## GG119 ROAD SAFETY AUDIT RESPONSE REPORT

Project Title:	Main Avenue, Cowlersley
Project Team:	TPS Consultants Ltd
RSA Report Stage	Stage 1
RSA Organisation:	Sevenairs Consulting
RSA Report Reference:	2025-10 Cowlersley RSA1 – Revision 0
RSA Report Issue Date:	05.10.2025
Report Title:	<a href="#">Main Avenue, Cowlersley RSA Response Report</a>
Reference:	P2445_20251010_Main Avenue, Cowlersley_RSA Response Report

This Road Safety Audit Response Report relates to a Stage 1 Road Safety Audit carried out on a proposed residential housing layout to provide 57 new homes in Cowlersley, Huddersfield. The scheme includes the proposed highway layout, which includes a spine road connecting Main Avenue and Windsor Road, three shared private driveways associated footways, driveway crossings, visitor parking laybys and mitigation works outside the school including waiting restrictions, as well as school keep clear markings.

PROJECT / CLIENT Kirklees Cluster Sites Main Avenue, Cowlersley		PROJECT NO. N81-3084	
DRAWING TITLE Proposed Materials and External Finishes Plan		DRAWING STATUS Planning	
PROJECT LEADER	DRAWN BY GP	CHECKED BY IDP	DRAWING REVISION P2
SCALE 1:500 @ A1	DATE 22.10.2024

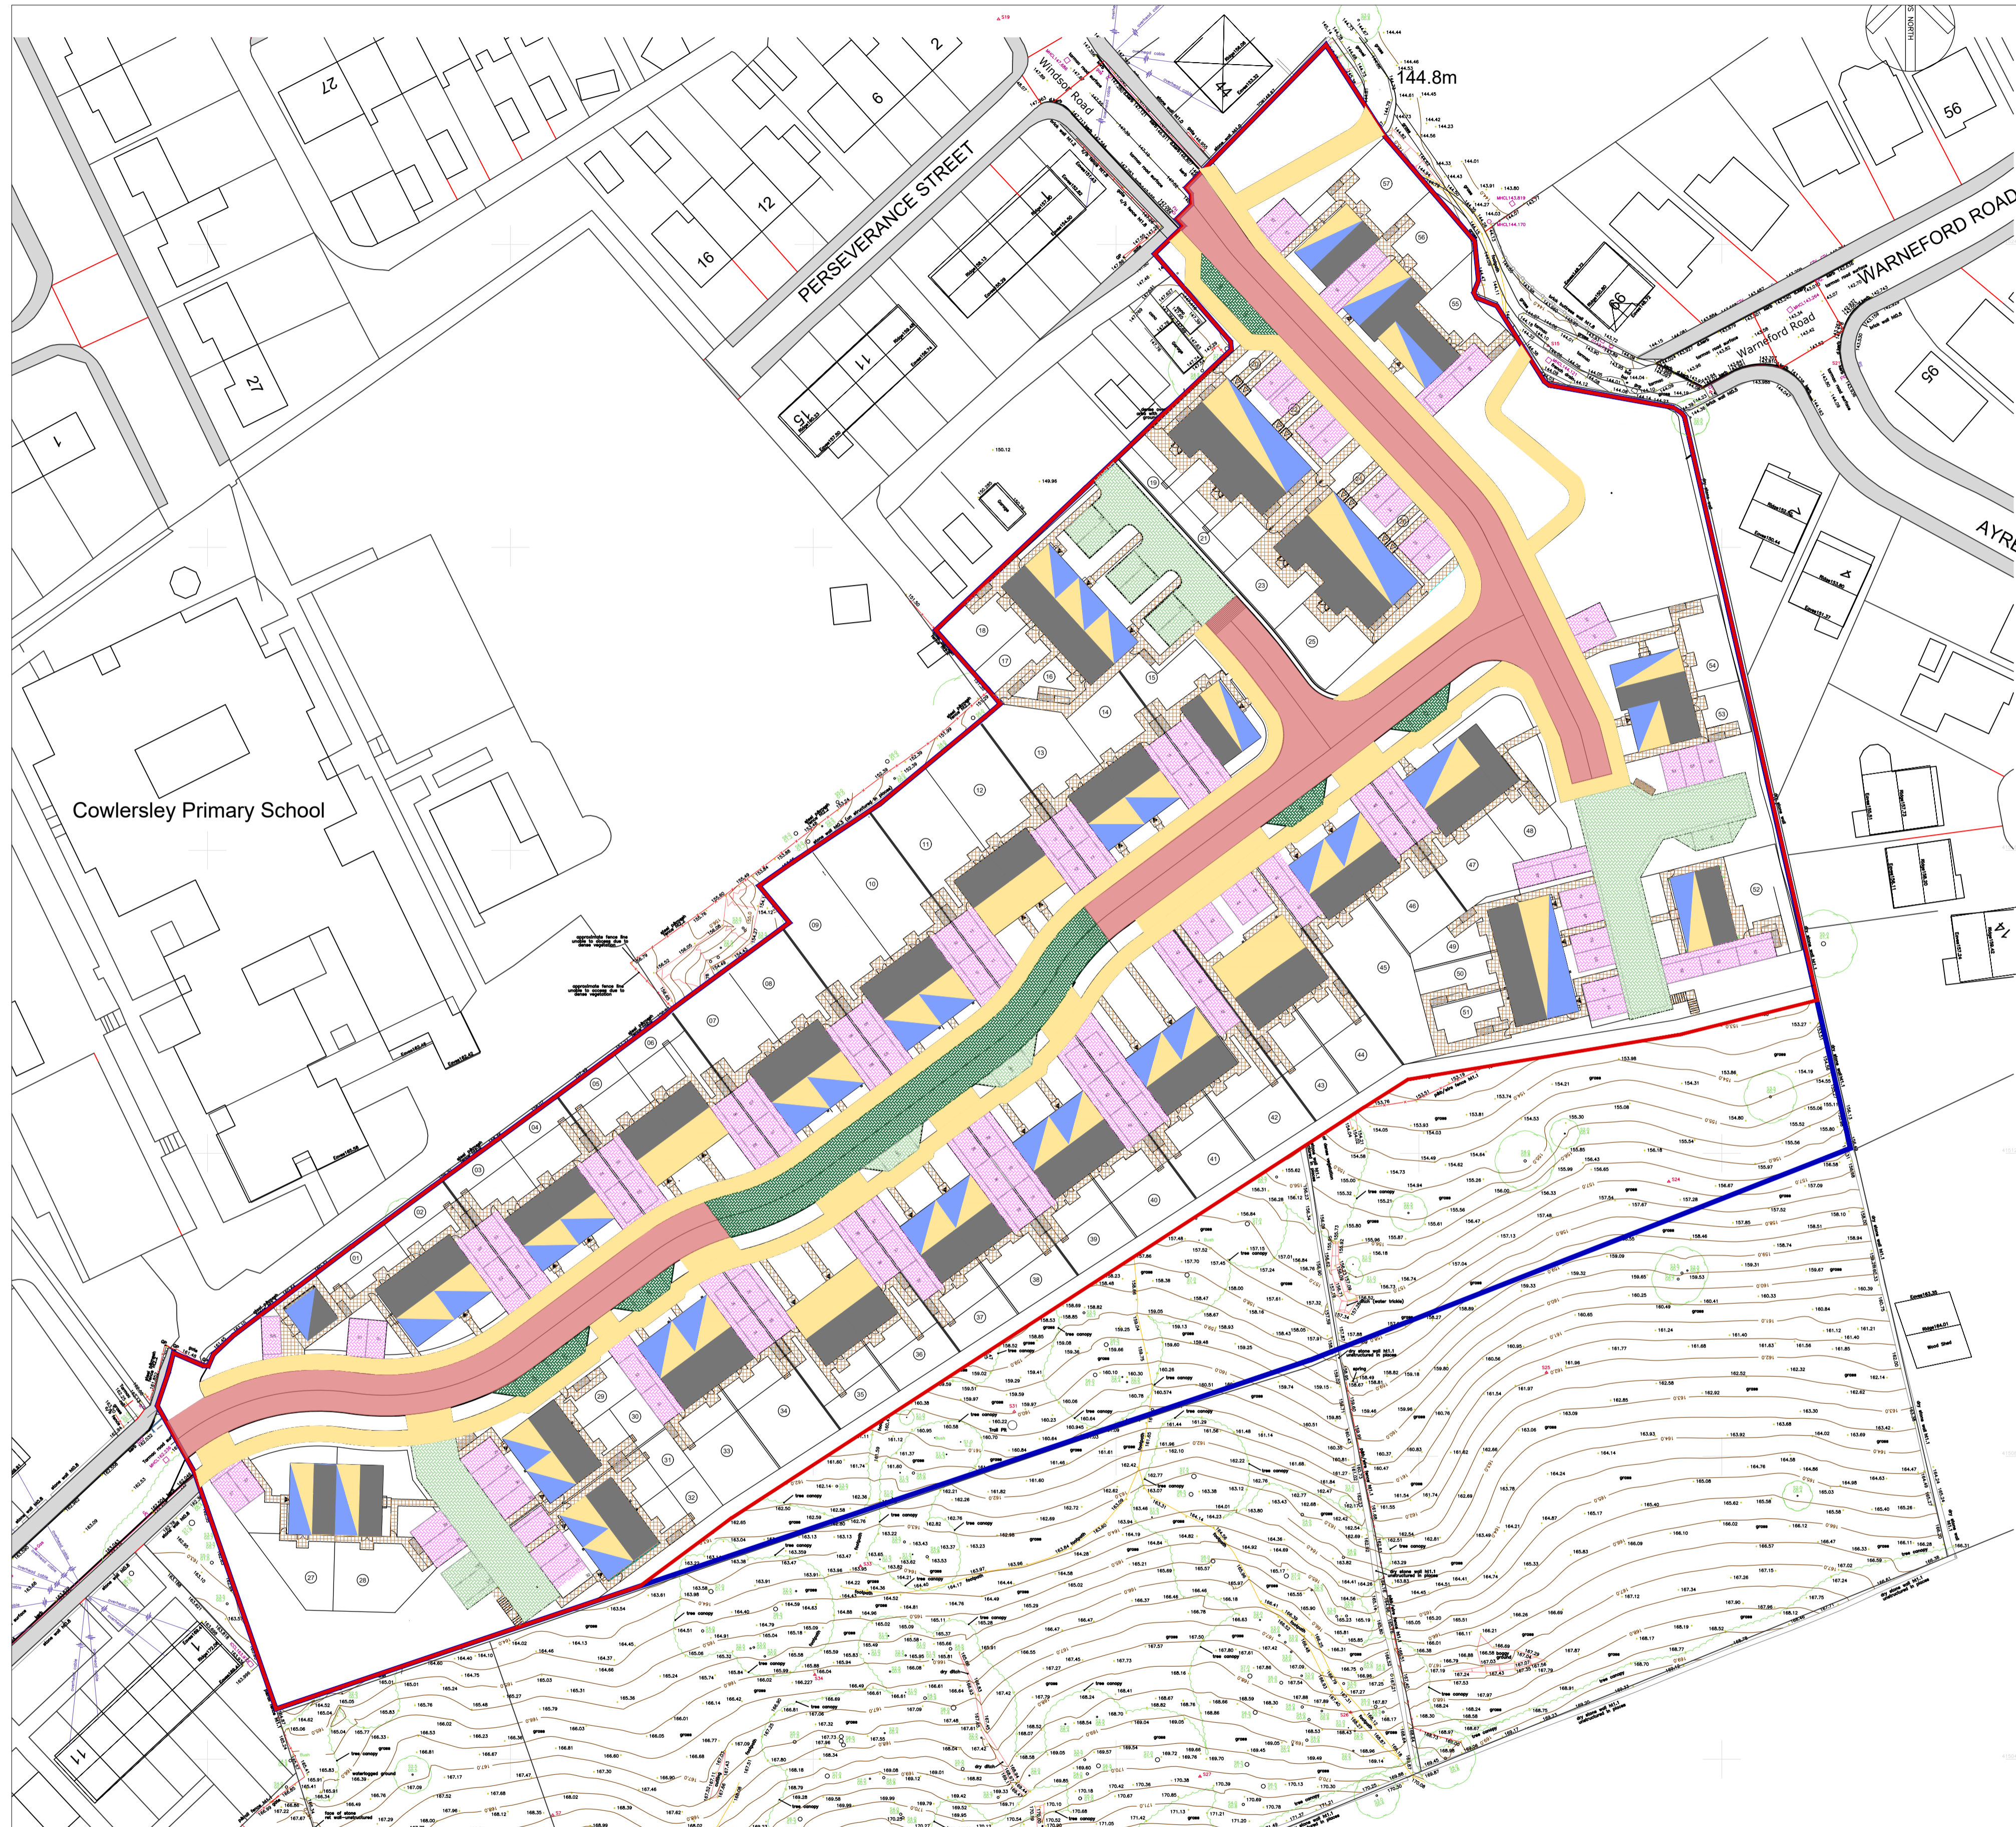
**Location:** Roads 1 & 3

**Detail:** There are desire lines for pedestrians between footways which have no provision for pedestrians with mobility issues, specifically those users with prams, wheelchairs or mobility scooters. The alternatives for these users may require them to use drop kerbs provided for driveways which are often not flush or to cross at locations where visibility to approaching vehicles may be otherwise compromised. This lack of dropped crossings on desire lines may increase the risk of collisions involving users with mobility issues.

It is recommended that a dropped pedestrian crossing with (ideally) tactile paving is provided at these locations. Specific locations will need to consider the risk of vehicle overrun as well as damage to the tactile paving by large vehicles, in particular refuse collection vehicles.

- Across Road 1 – Near the junction with Road 3
- Across Road 1 – Somewhere near Plot 6
- Across Road 1 – Somewhere near Plot 27
- Across Road 3 – Near the junction with Road 3 to link with footway to Warneford Road.

Accepted. It has been agreed with the planning case officer that these improvements do not need to be shown on the site layout at this time. These will be considered further as part of the S38 process, with all details provided at this time.

Footway dropped crossings to be incorporated into the site layout at the junctions mentioned at all locations, these will be designed to a suitable standard a detailed design stage.

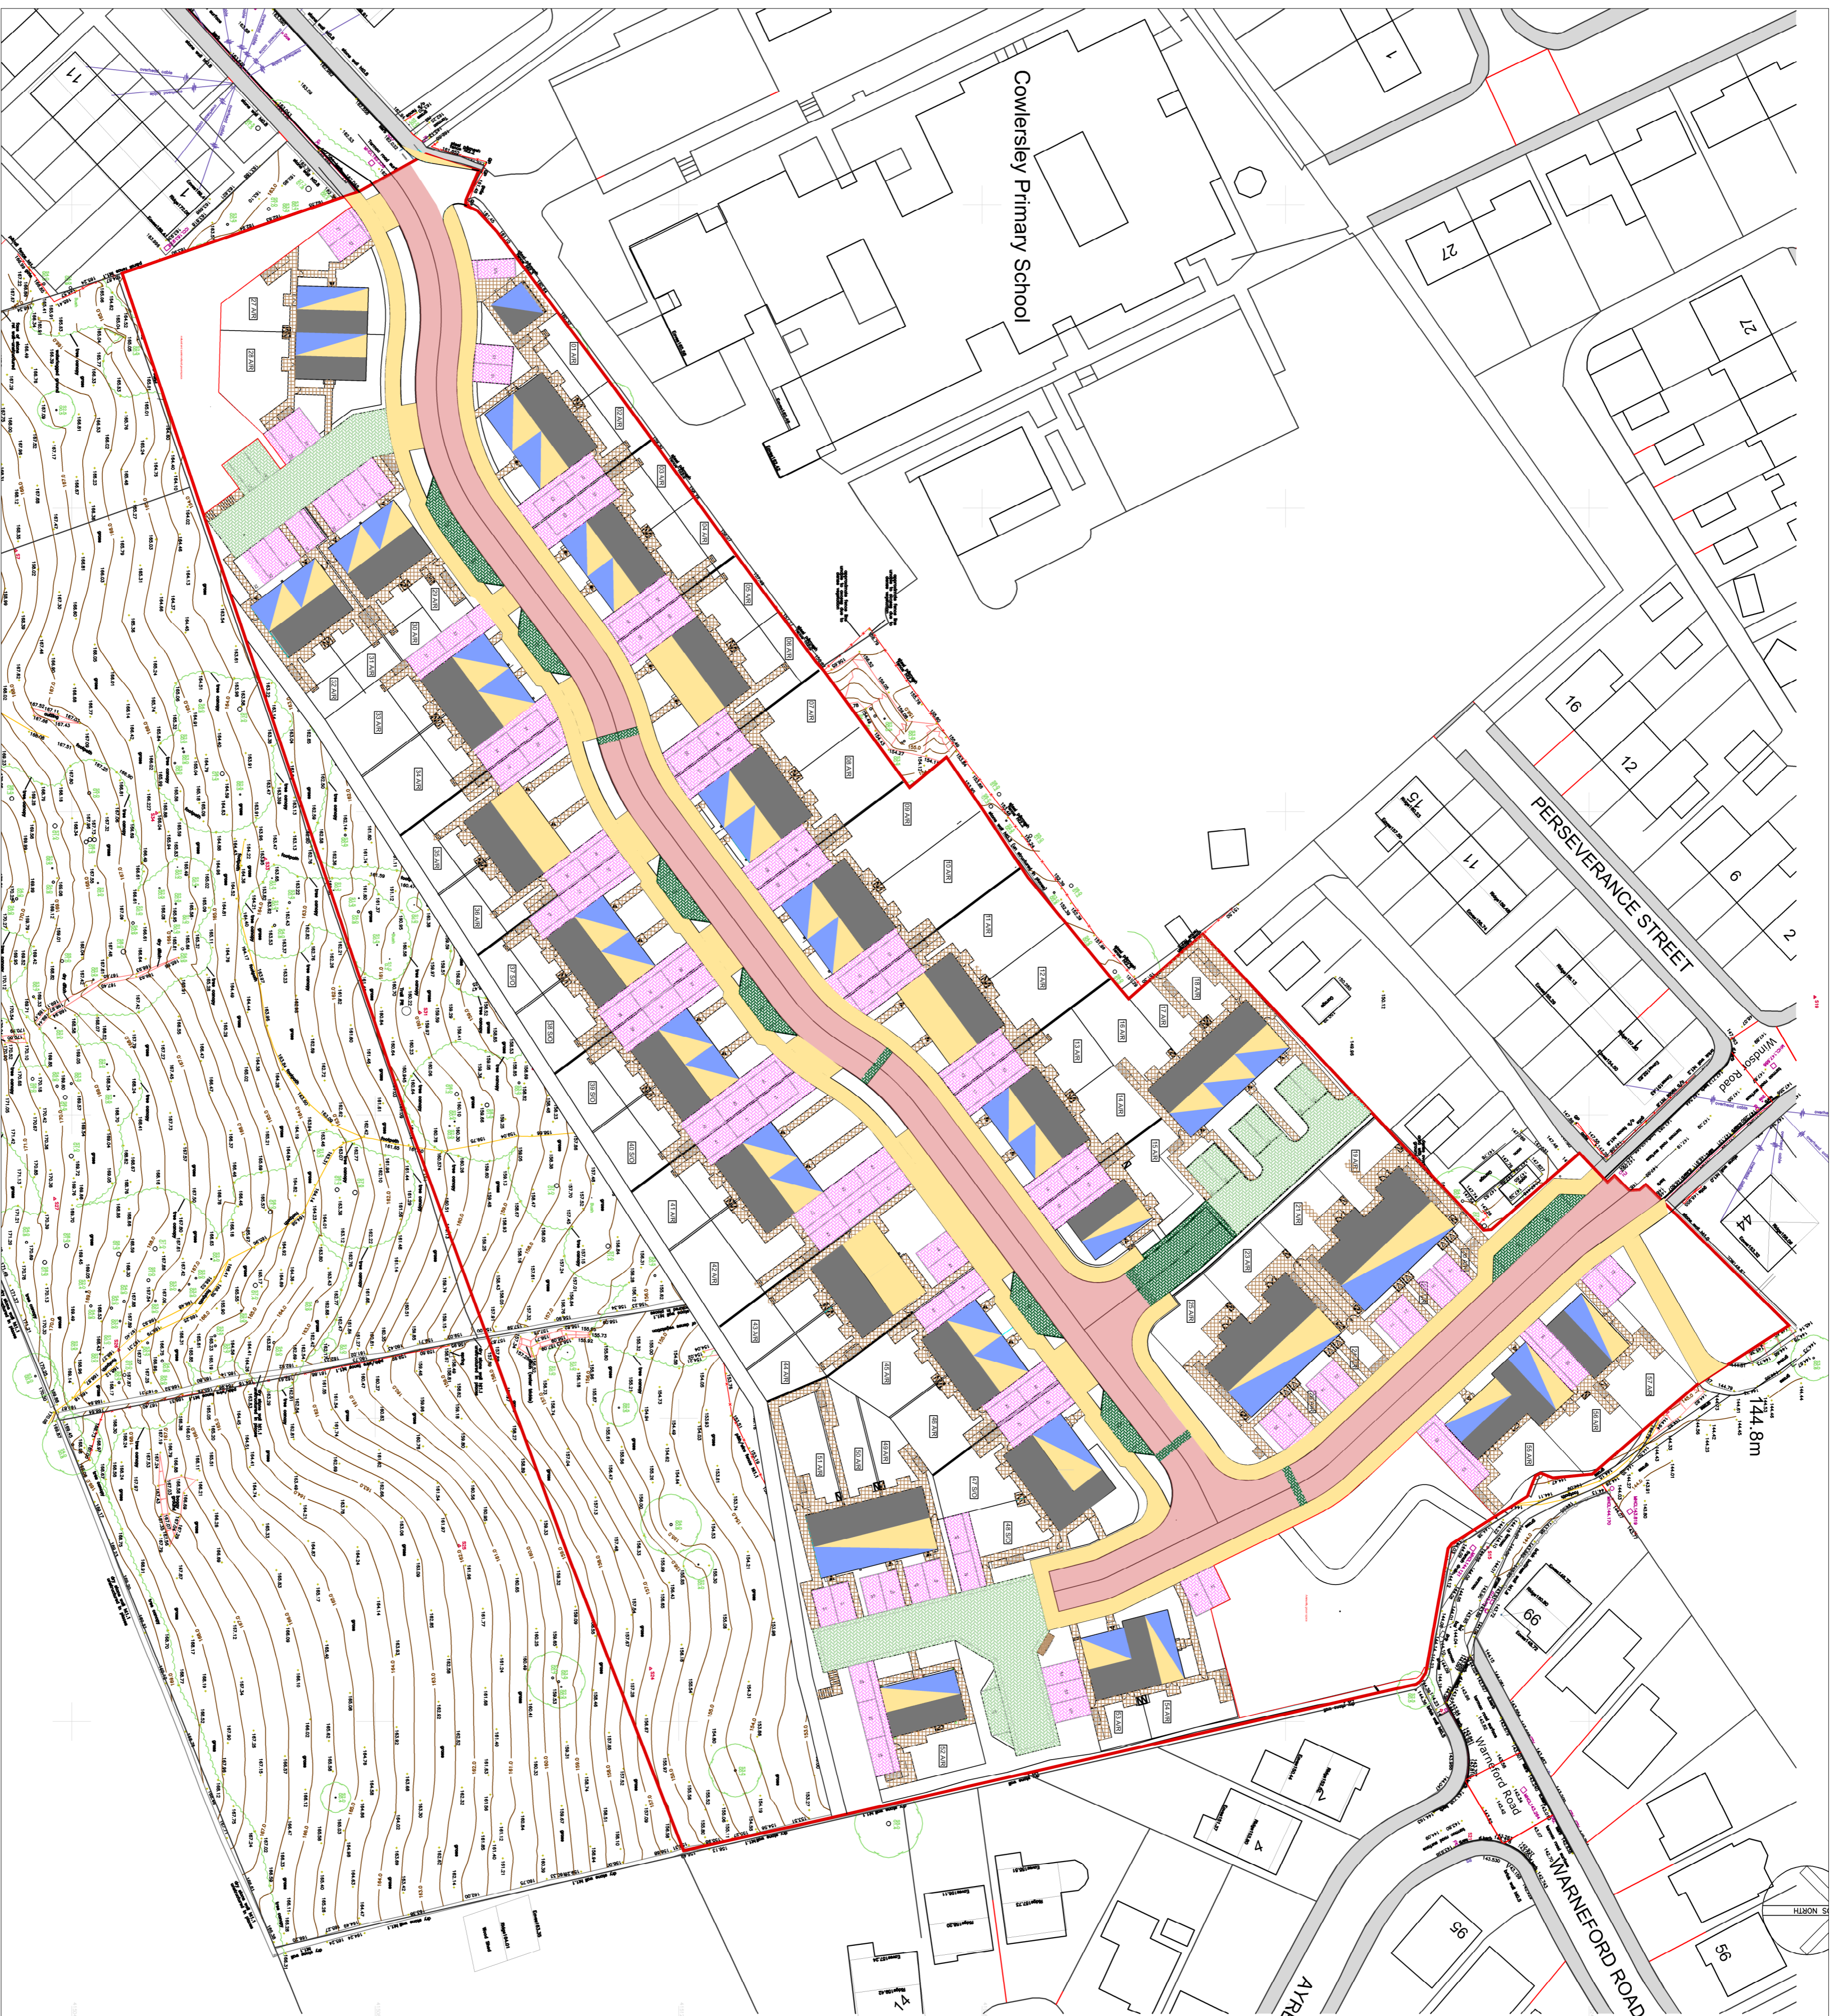
**Location:** Route between Road 3 and Warneford Road.

**Summary:** Specific Road Users – Insufficient provision for users who rely on mobility aids may increase collisions involving this user group.

**Detail:** A footway is shown linking the development to Warneford Road. It is unclear at this early stage if the footway will form a contiguous route between the development and Warneford Road. The audit team noted that the existing footpath does not provide for pedestrians who rely on mobility aids such as wheelchairs, scooters, prams etc and is not in a good state of repair. Also, there are third party planters blocking the footways. Furthermore, the existing provision requires able footed pedestrians to step into the carriageway area of Warneford Road to transition between footways. Insufficient provision for pedestrians and users who rely on mobility aids may increase collisions, trips and falls involving these user groups.

It is recommended that a contiguous paved footway route is provided to Warneford Road and that access to the footways is protected from parked vehicles.

Accepted. A footway is being provided, as shown on the proposed site layout up to the redline boundary of the site, connecting with the Public Right of Way which runs along the northern boundary of the site. This will be maintained by a Management Company. The pedestrian link as shown is going through an area of public open space with a 1:12 gradient. Improvements to the public right of way are being provided, in response to specific comments from the PROW officer and this will be dealt with via a commuted sum and picked up in the S106 agreement.

A footway is to be incorporated with the design requirements to be approved by the Councils PROW team.
